APA Reference: 510290

Your Reference: SSD-60247221

**RE: WALLABY CREEK WIND FARM**

Thank you for your referral request received on 16 April 2026 in relation to the Wallaby Creek Wind Farm proposal – Ref SSD-60247221.

Figure B 1: Site Layout in relation to APA Gas line

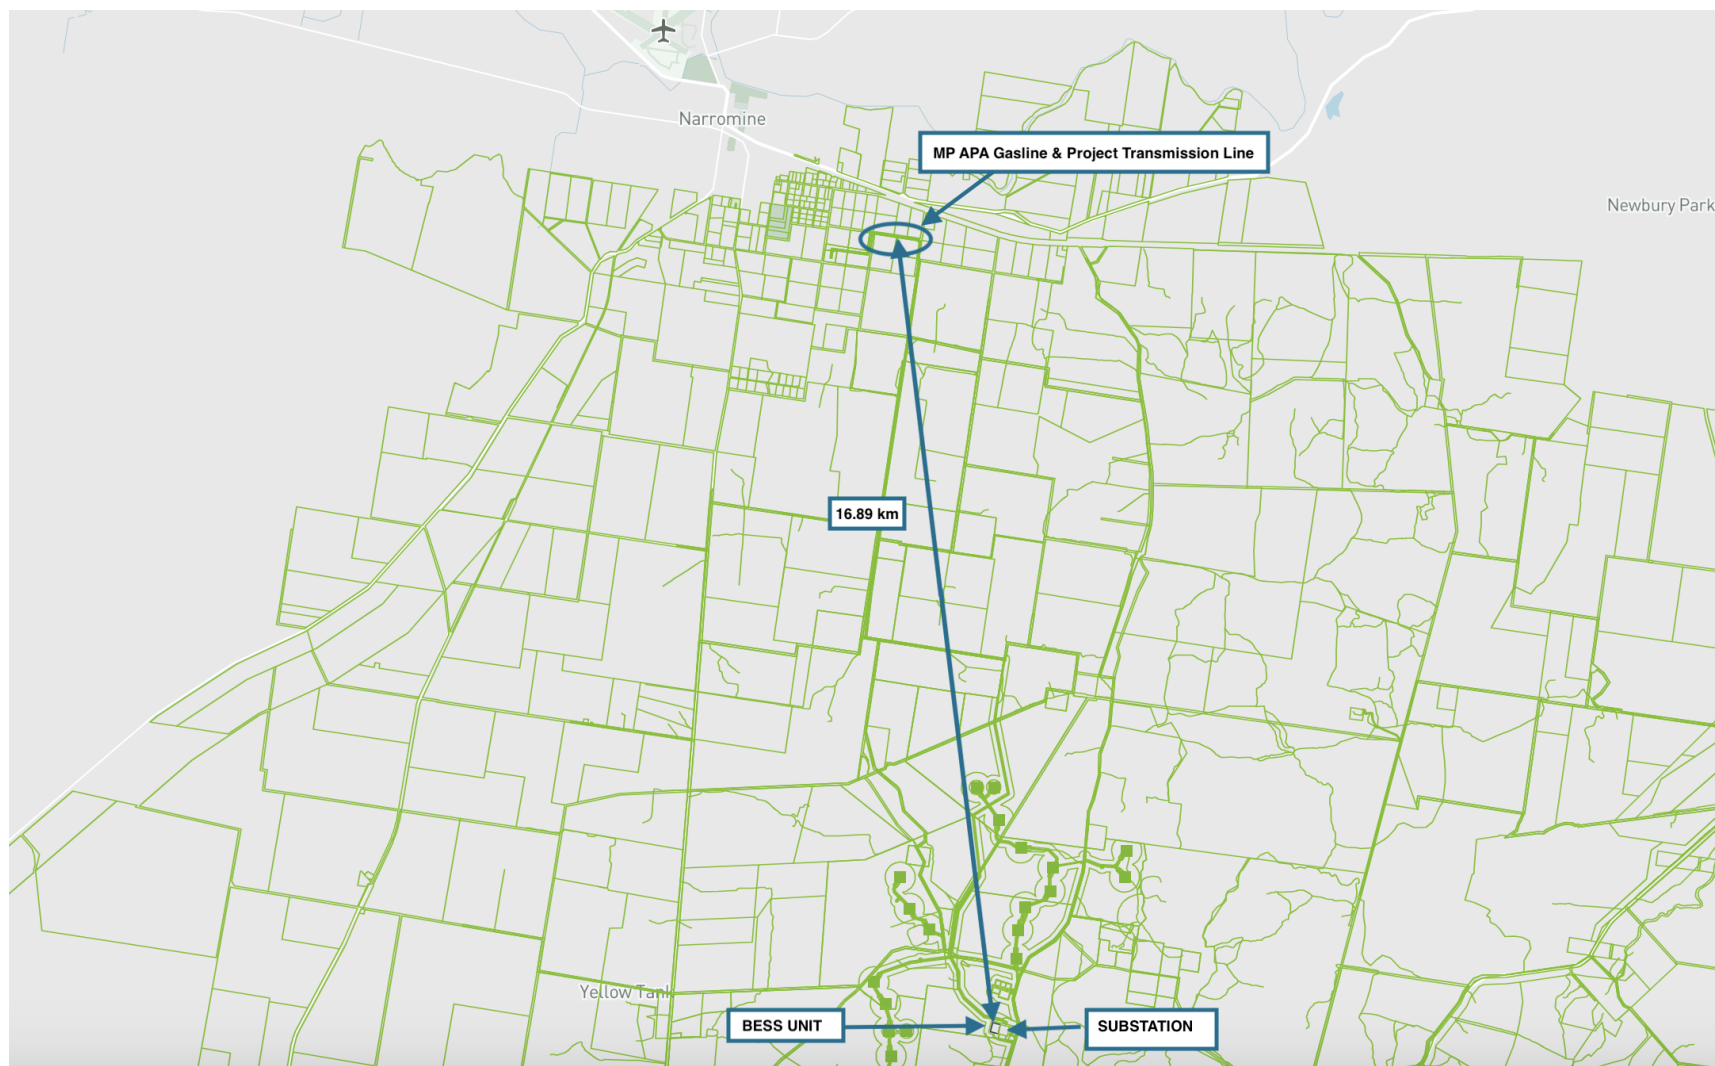
Whilst the bulk of the proposed Wind Farm is located approximately 9km from APA's high pressure gas pipeline, the proposed transmission line linking the proposal to the grid, is located near APA's pipeline in Dappo Road and Gainsborough Road. There is a risk when locating transmission powerlines near existing gas transmission pipelines that they may impact the existing metallic gas pipeline. As such APA proposes the following conditions to ensure the ongoing safe operation of the existing gas pipeline.

1. Prior to the development commencing, and to inform detailed design, the developer must conduct electrical hazard studies in accordance with (the requirements of) Australian Standard 4853-2012 Electrical Hazards on Metallic Pipelines (for Low Frequency Induction and Earth Potential Rise). The developer must address any relevant requirements and any recommendations and/or actions must be implemented to the satisfaction of the pipeline licensee/operator (APT Petroleum Pipelines Pty Ltd).

2. Buildings, structures, roadway, pavement, pipeline, cable, fence or any other improvement on or under the land within the gas transmission pipeline easement must not be constructed without prior consent in writing from the pipeline licensee/operator (APT Petroleum Pipelines Pty Ltd). No structure or vegetation will be permitted on the easement that prohibits maintenance of line of sight along the pipeline easement.
